# CITY OF ALBUQUERQUE

September 3, 2021

**Re: Montage Units Traffic Impact Analysis, draft final**  
Dated August 25, 2021 (R16D099)  
Received August 27, 2021  
Review comments from CABQ Planning Transportation

Site Plan

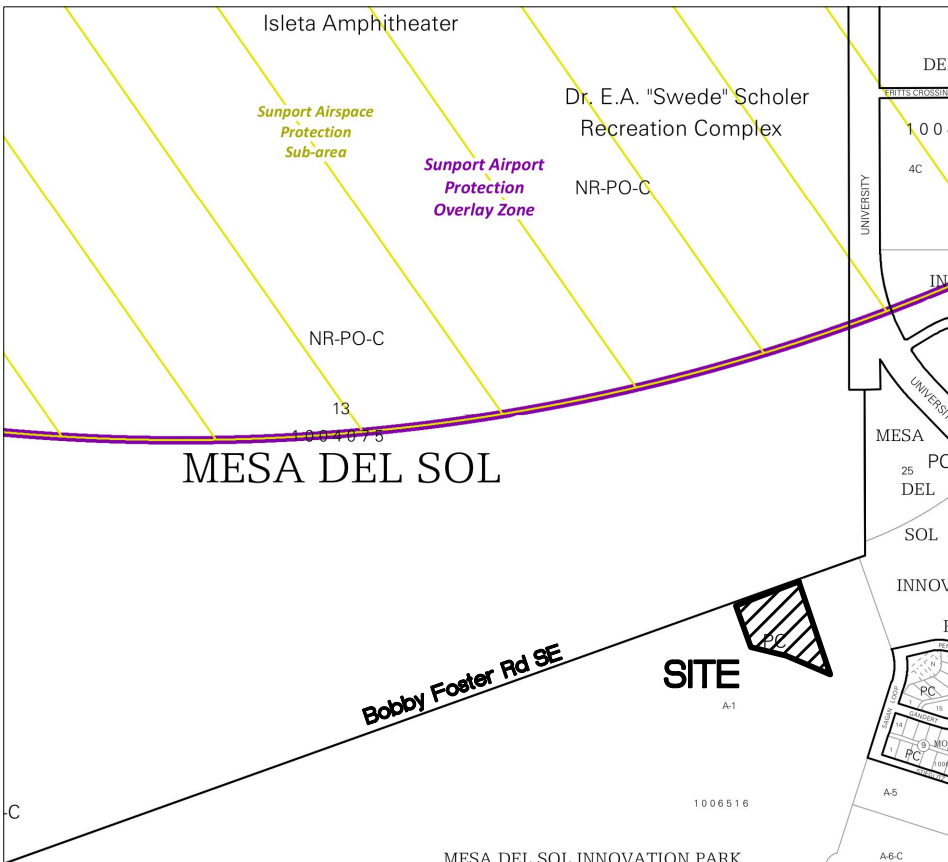
- Provide access point analysis for all access for Montage from University Blvd. and also Bobby Foster Rd. Include site plan drawings with sufficient detail depicting all access points to these roads. The site plan for the Gateway Apartment dated 7/25/2021 shows a main entrance on University Blvd. between Bobby Foster Rd. and Arbus Dr. The access to the Gateway Apts. as well Arbus Dr. and any other access that are not in the draft final report are to be included in the final report.

- Provide a drawing showing the proposed geometric relationship with the connection between Montage Units and the Regional Sport Complex specifically Diebenkorn Dr, Newhall Dr, Sagan Loop, Multi-Family Housing driveway.
